## Application for a Non-Material Amendment Following a Grant of Planning Permission

Area 12 B

Reserved matters application for the siting, scale, layout and appearance of 81 units together with garaging and associated infrastructure pursuant to planning permission ref: WP/15/00605/VAR

DETAILS 2B4P Apartment Block  
Floor Plans and Elevations

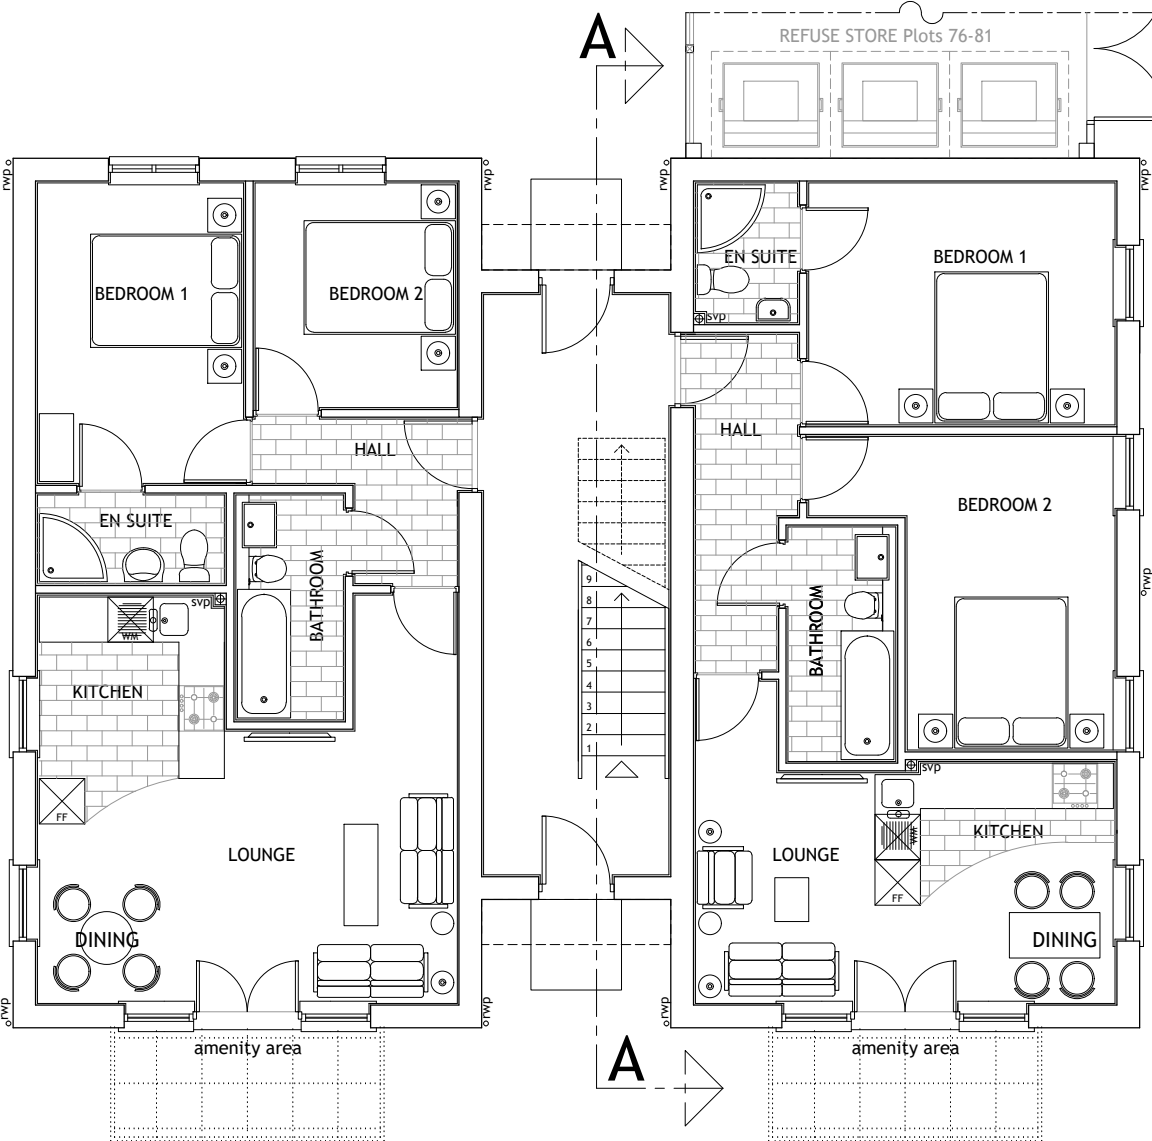
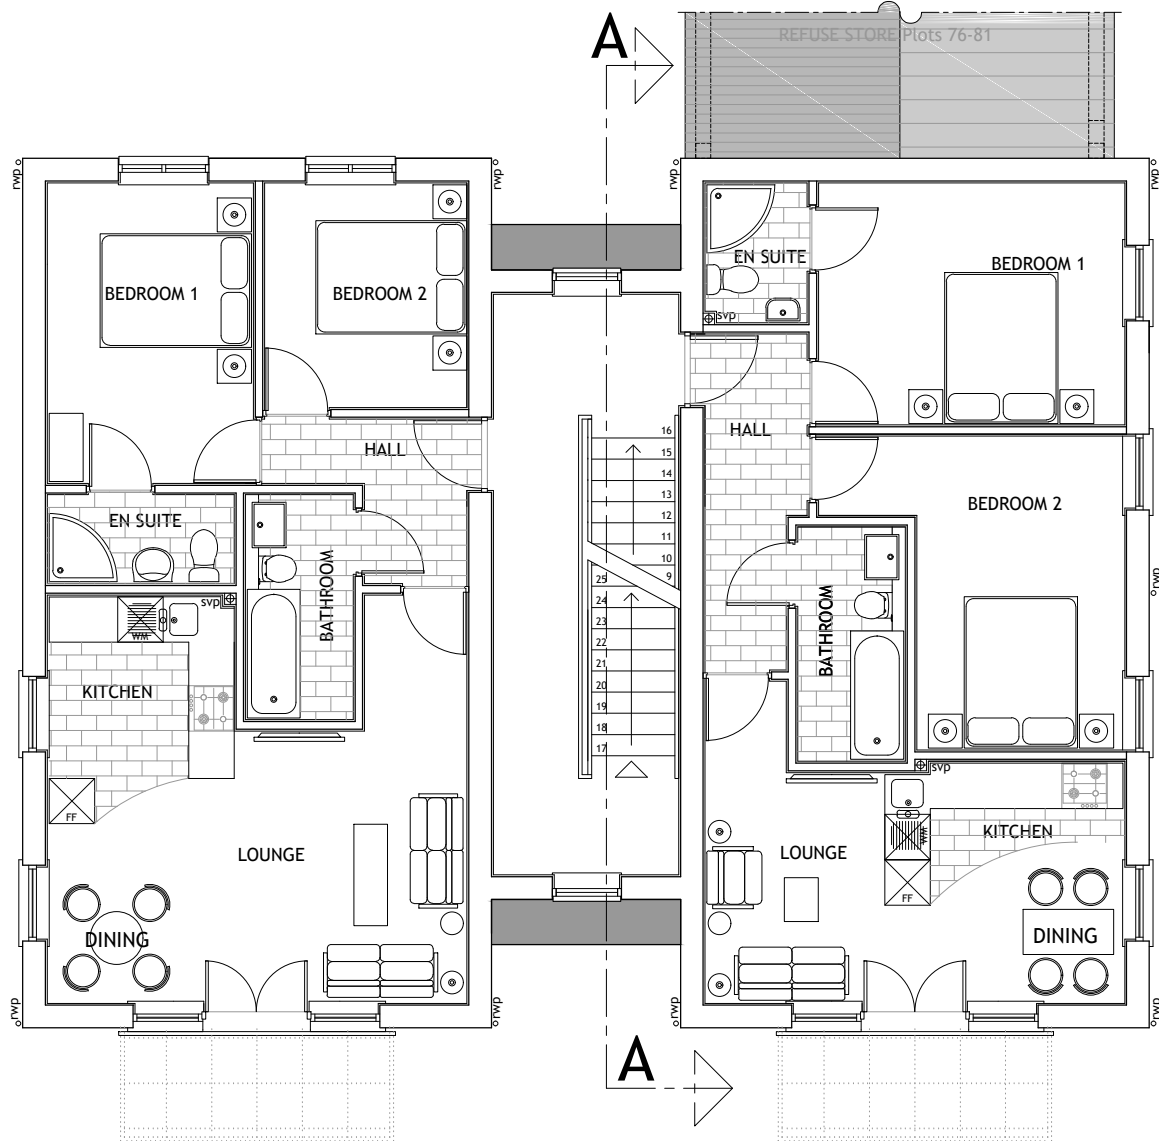
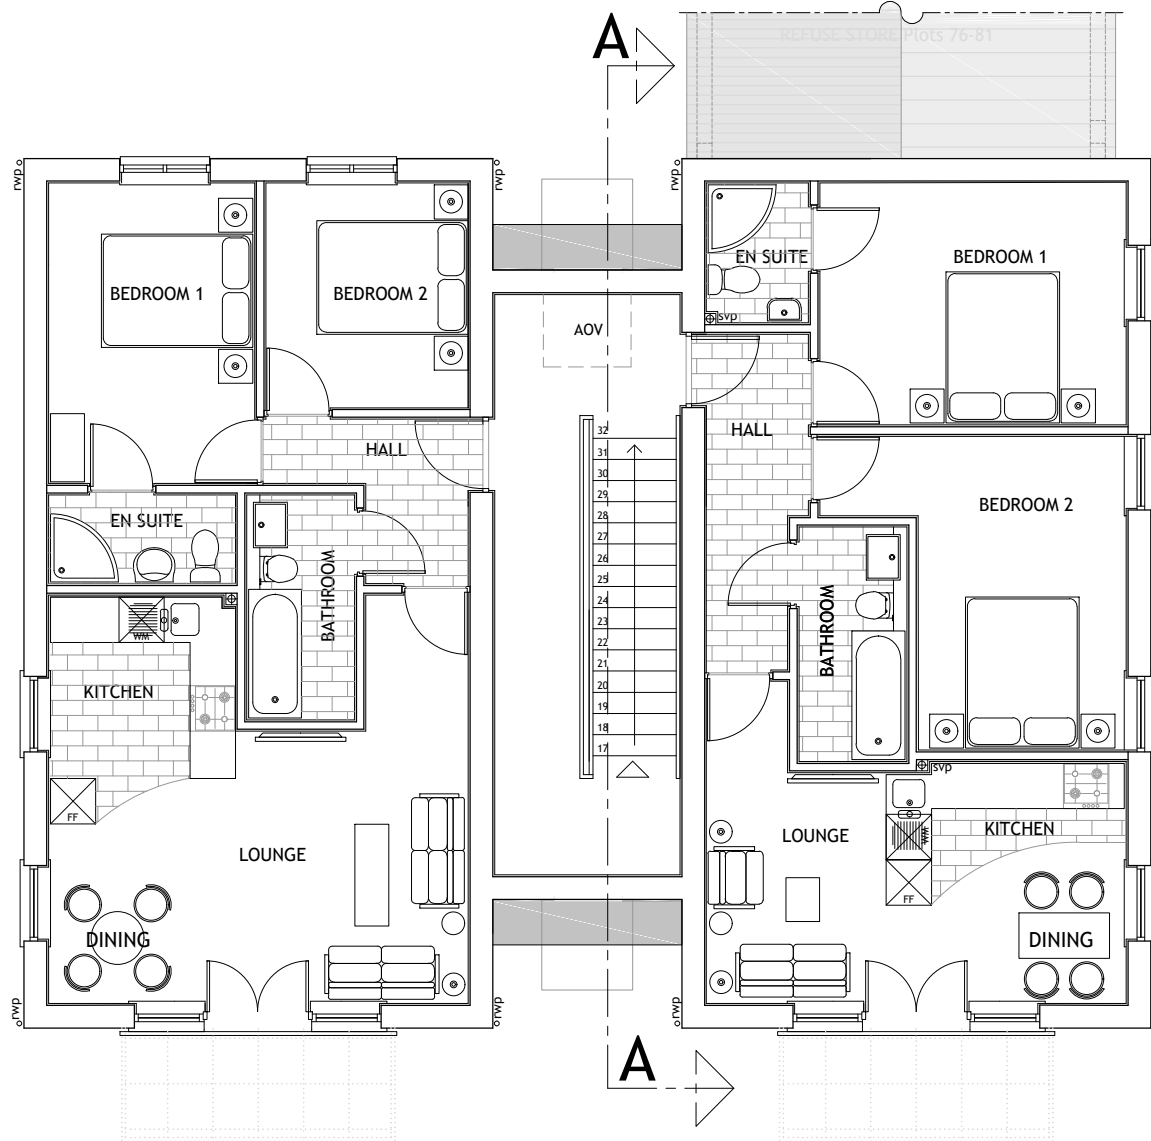
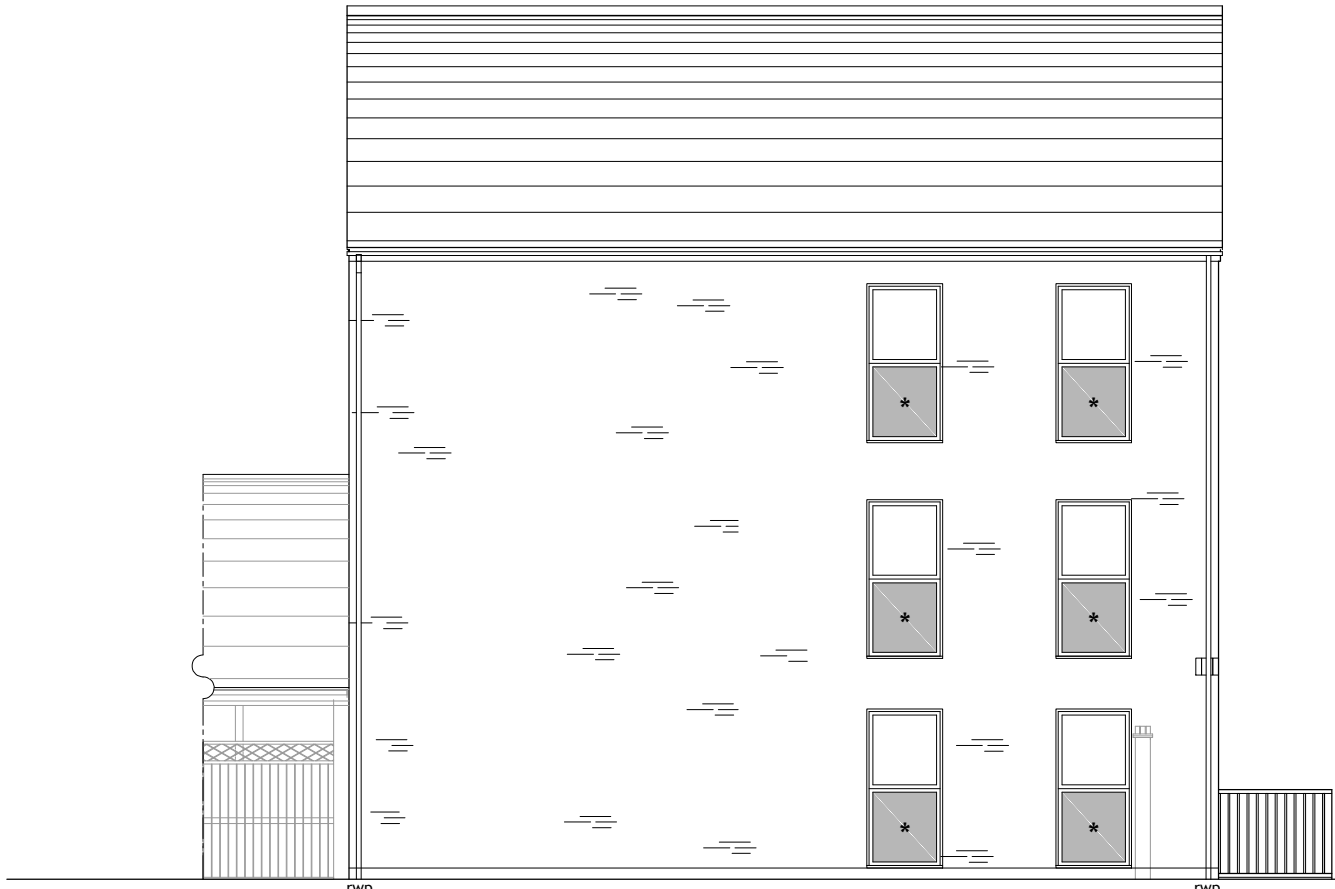
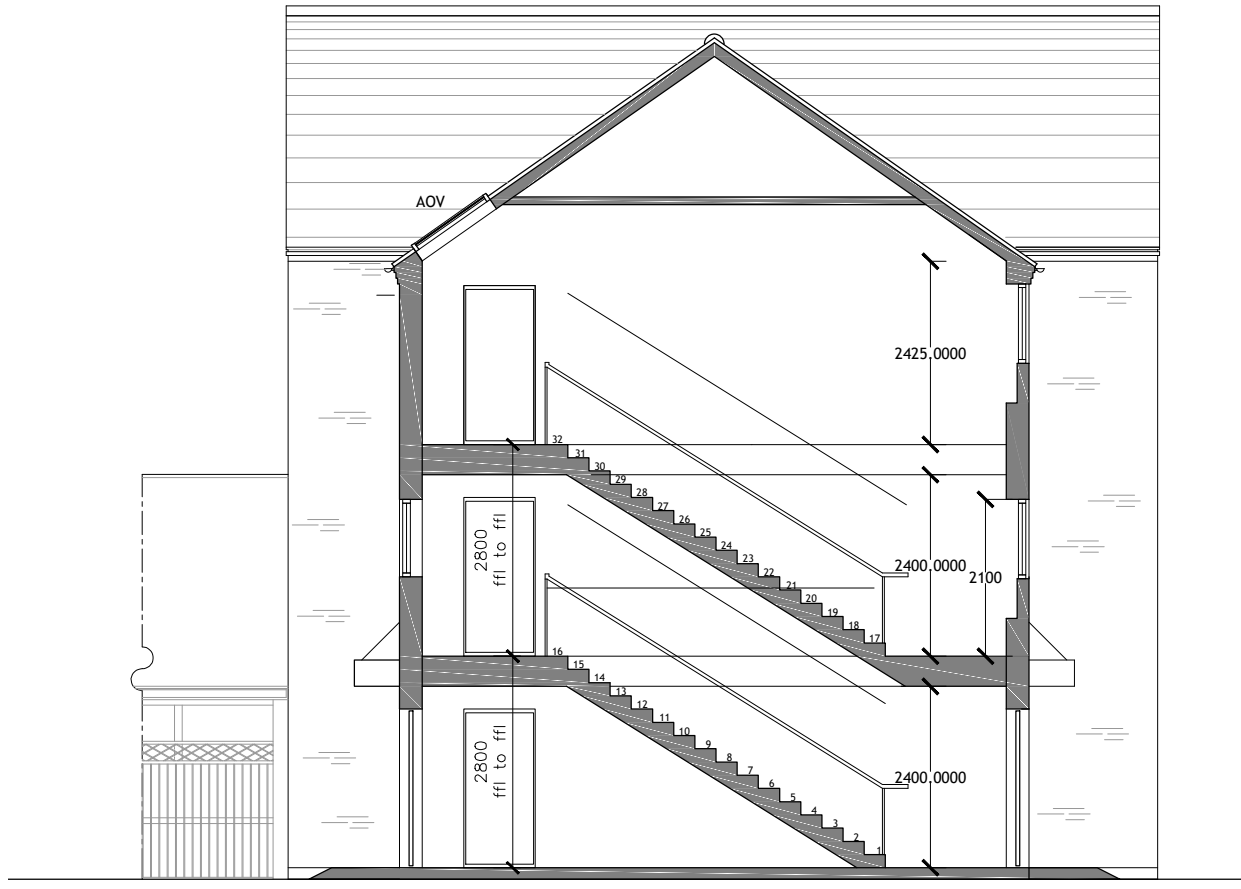
1. Alteration of window openings to 2B4P flat block to improve fenestration and introduction of a soldier course
2. Movement of plots block 25-28 by 1m
3. Hanging Morden plots 49/53/60 for building regulation purposes.
4. Alteration of buff brick due to availability.

The changes to the 2b4p flats are to improve the balance of the elevation to the key building by changing location of the window openings as well as introducing a soldier course detail to add interest. Movement of plots 25-28 is to ease construction issues due to the proximity of the flat block to the footpath. Hanging plots 49/53/60 is for building regulation purposes due to fire regulation requirements in relation to the proximity of the glass bay windows.

18908 102F - 2B4P Apartment Block C Floor Plans and Elevations  
18908 1001N - P12B Planning Layout  
18908 1002J - P12B Car Parking Strategy  
18908 1003I - P12B Refuse Strategy  
18908 1004J - P12B Boundary Treatments Layout  
18908 1005N - Street Scenes AA BB  
18908 1006N - P12B Materials Layout
